Application No: FP/237/21/HH
Site Address: 42 Minton Road Felpham PO22 7JN
Description of works: Erection of single storey side and rear extension including the installation of front porch.

Thank you for your internet representation made on 15th November 2021 which has been recorded as an objection with the comments as follows:

Drawing Title:
PROPOSED PLANS AND ELEVATIONS

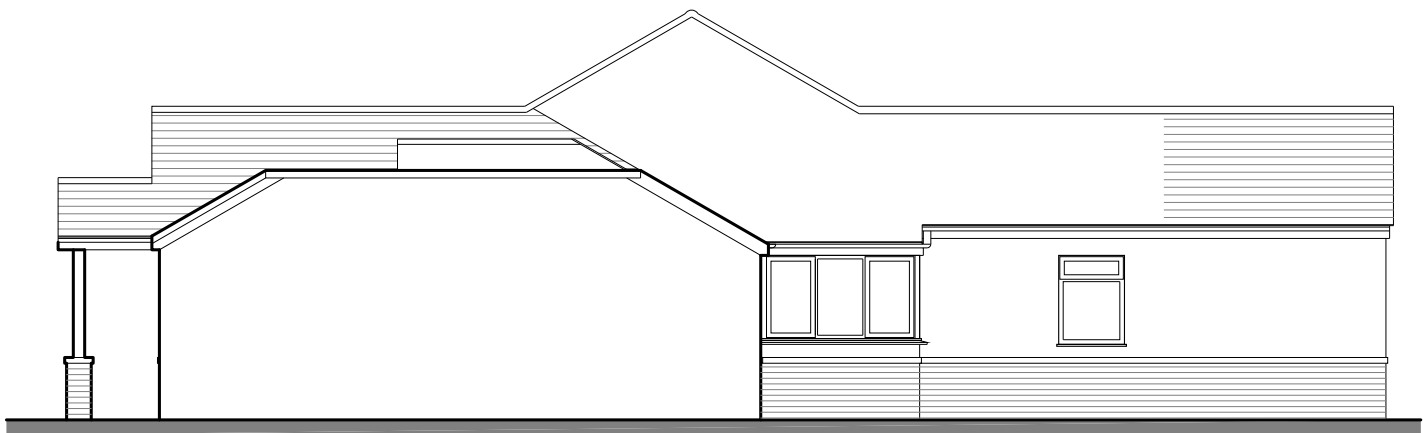
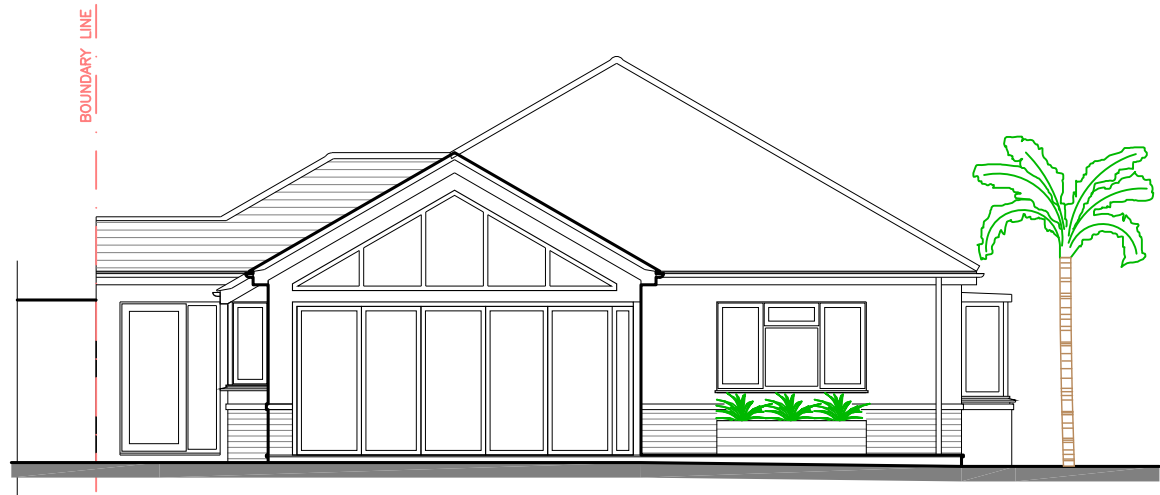
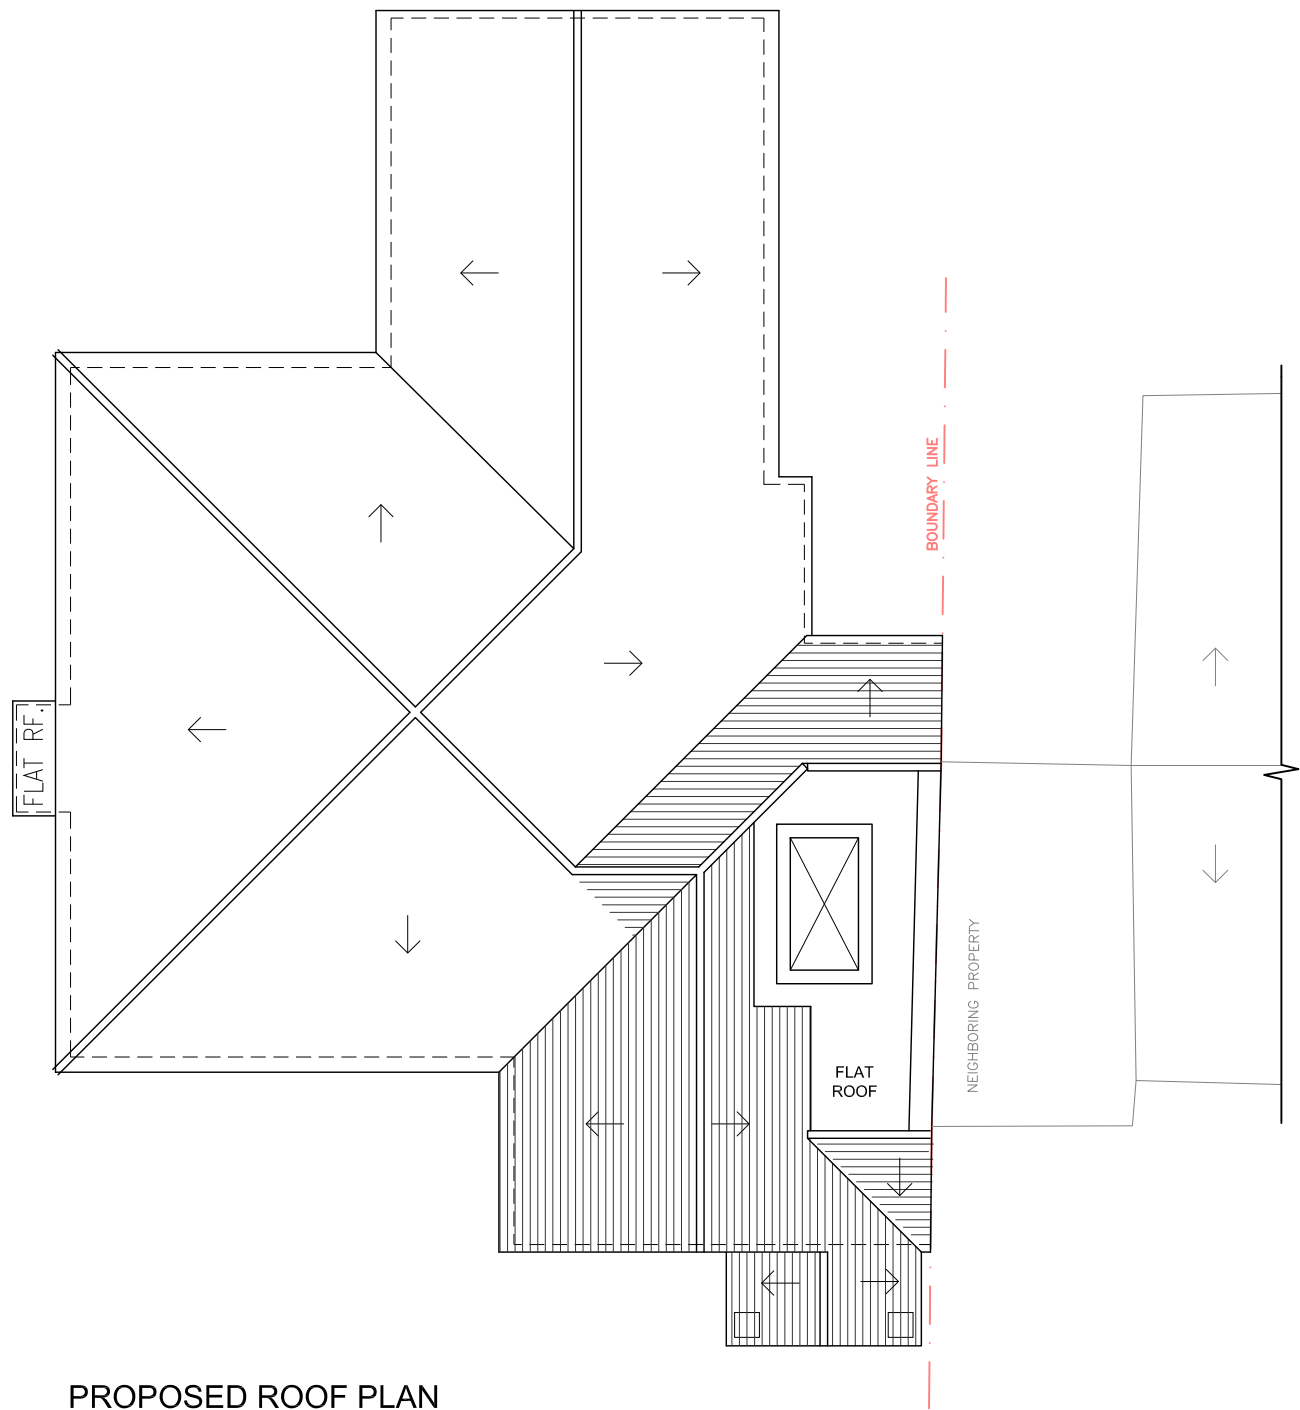
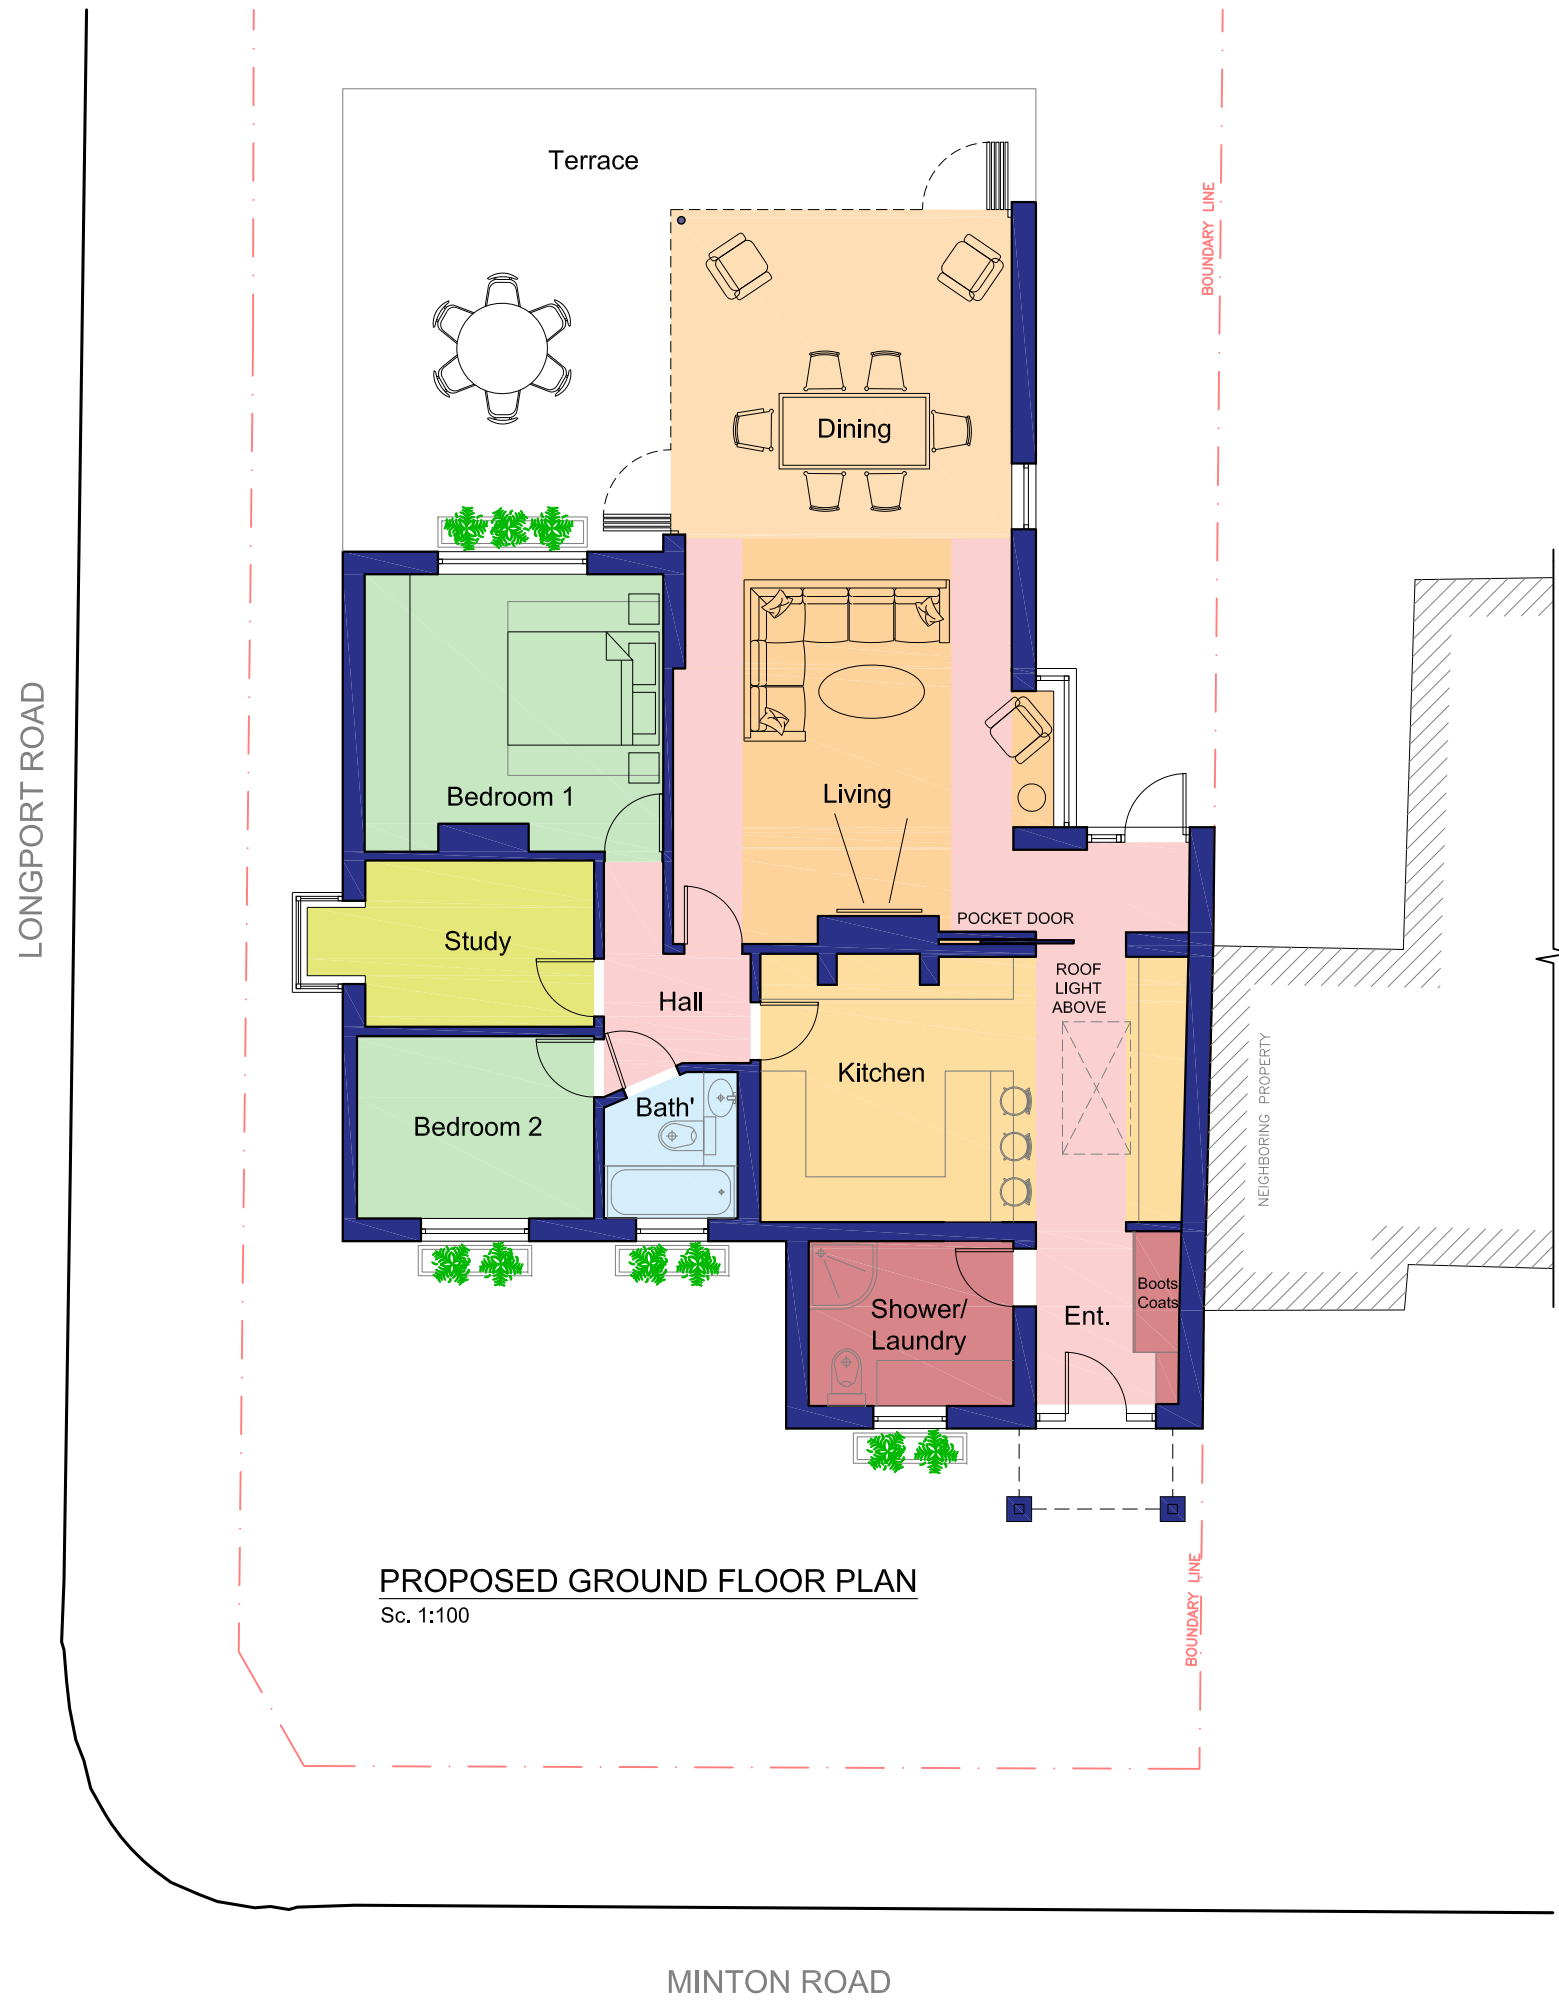
The proposed side extension effectively turns both houses (42 and 40 Minton Road) into semi-detached houses with no effective separation between them by closing a gap in the street scene. We feel this will have a detrimental effect on the value of both houses and is not in keeping with the overall design of Felpham Beach Estate which. Planning guidance offered by Arun DC provides clarity on side extensions and supports our view:

In streets characterised by small gaps between buildings, extensions must not close important gaps in the street scene by leading to a terracing effect or remove existing external access from front to back gardens. This can generally be ensured by keeping extensions at least 1 metre away from the side boundary of a plot at ground floor and 2 metres away at first floor and above. No part of the development should generally protrude further than the 70 degree line taken from the plot boundary.

PROPOSED SITE PLAN

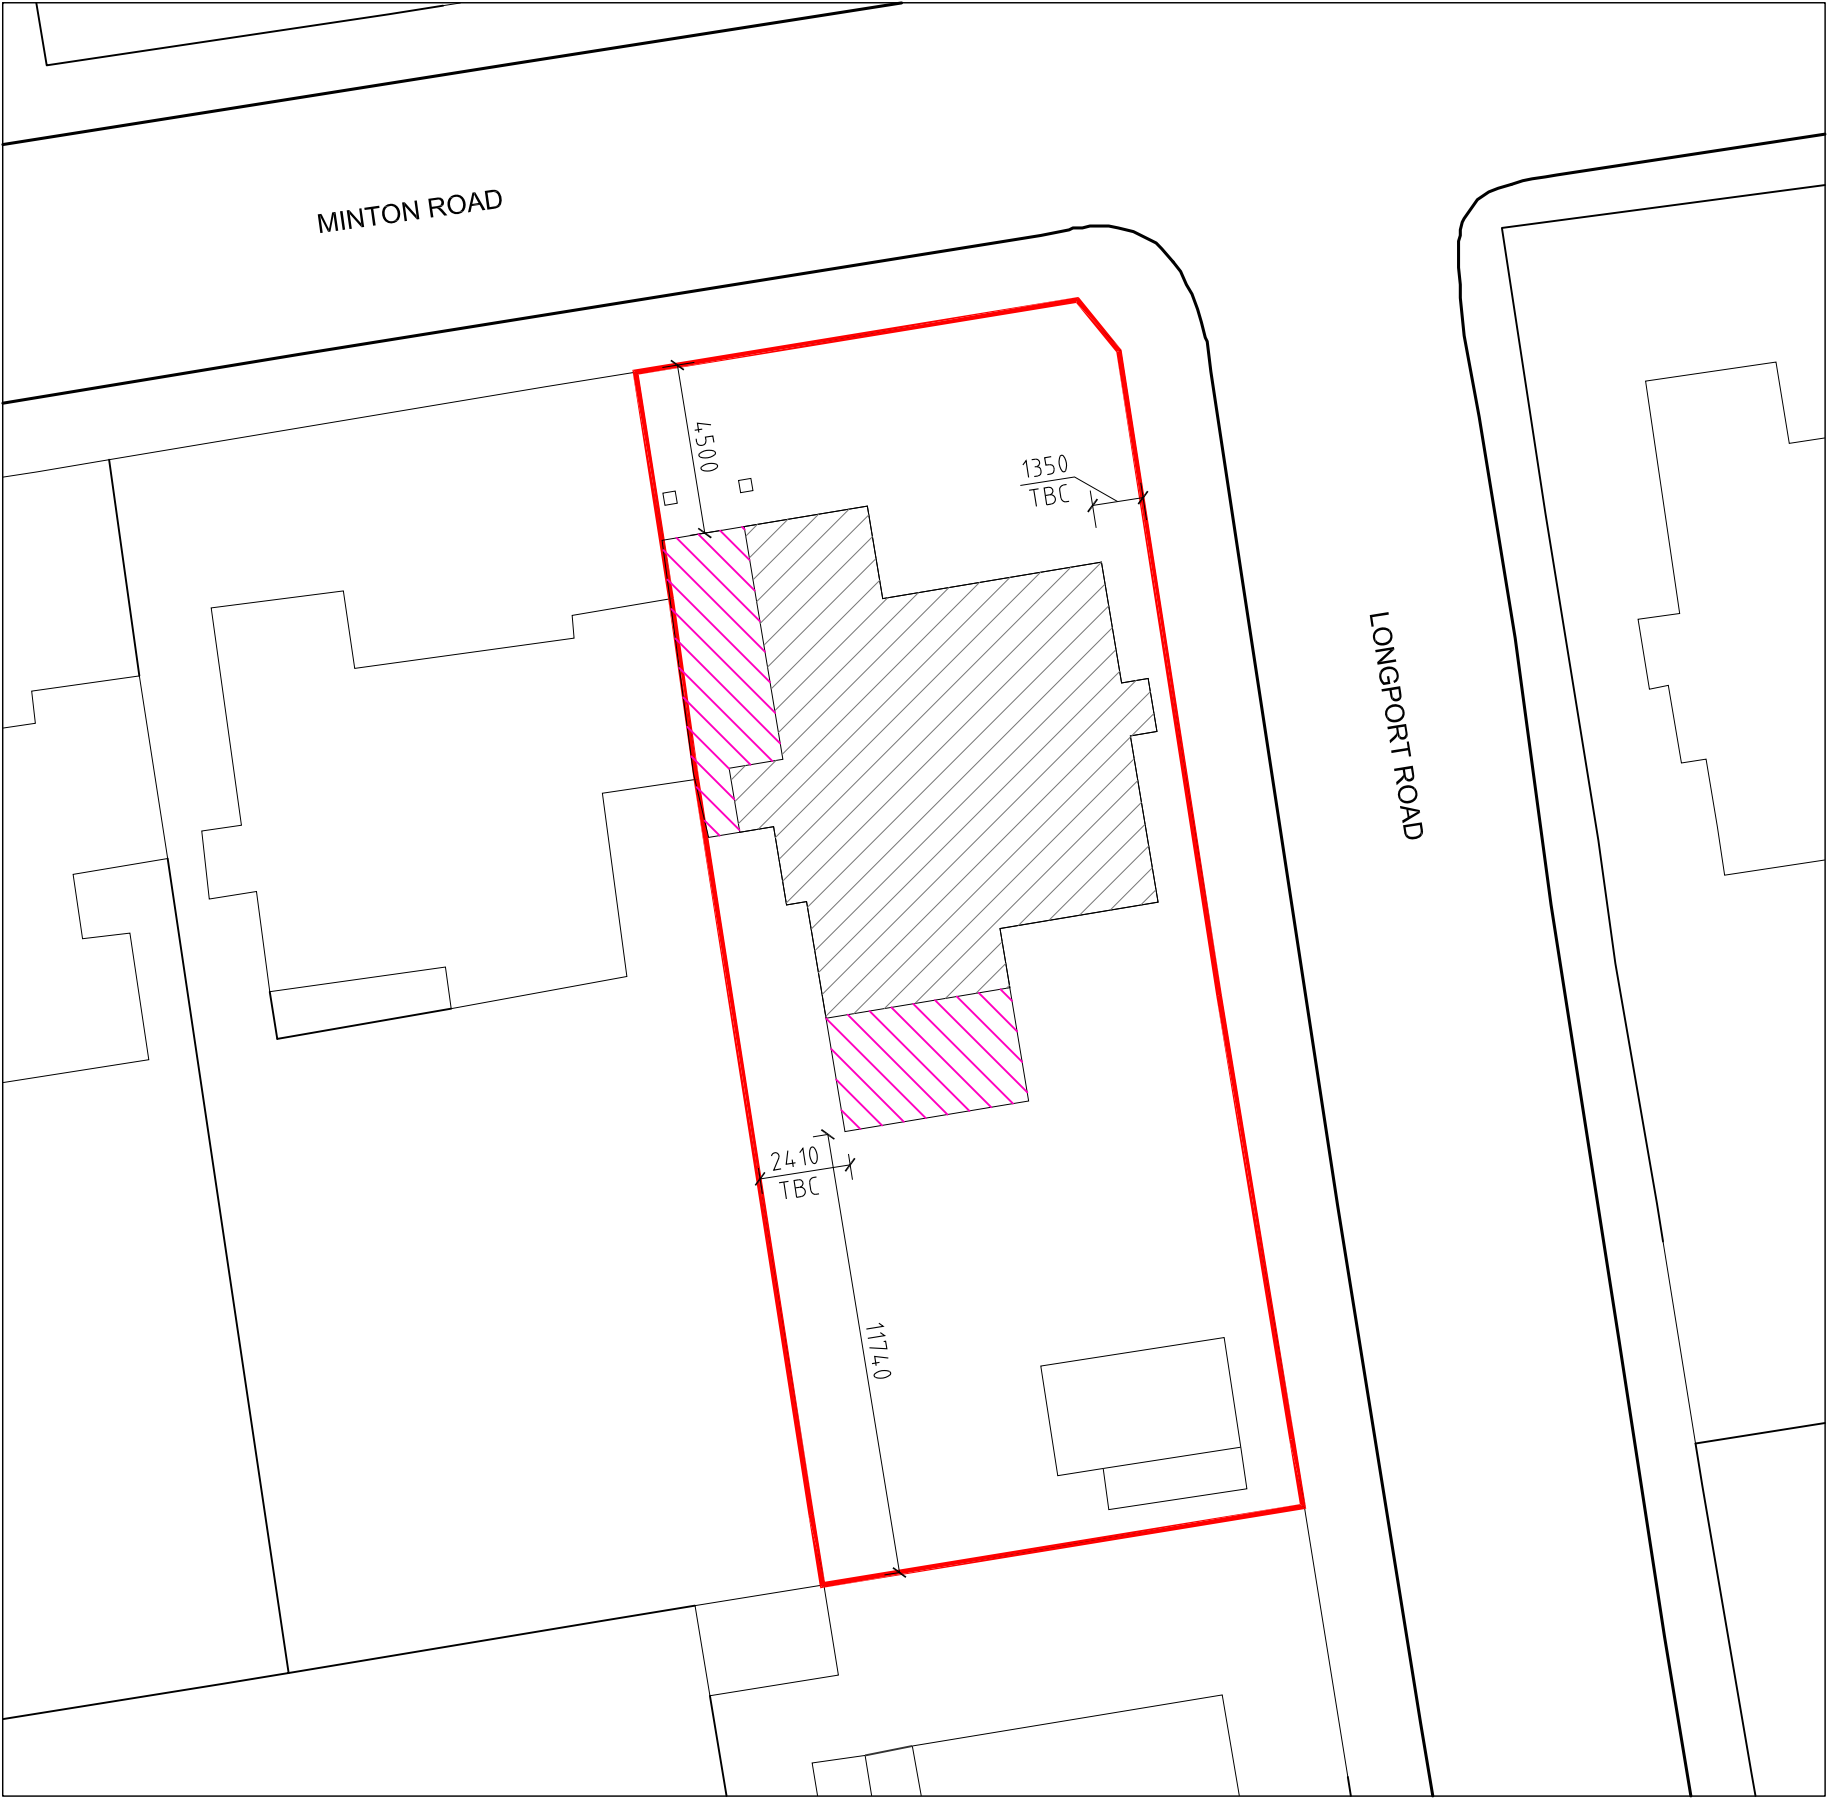
All developments should make good use of the available site and location. The size of any proposed development, whether of new properties or extensions to existing properties, should be appropriate to the size of the plot and the extent to which the development will 'urbanise' the street scene. Sufficient distances between properties must be maintained. The density and character of each part of the parish should be respected
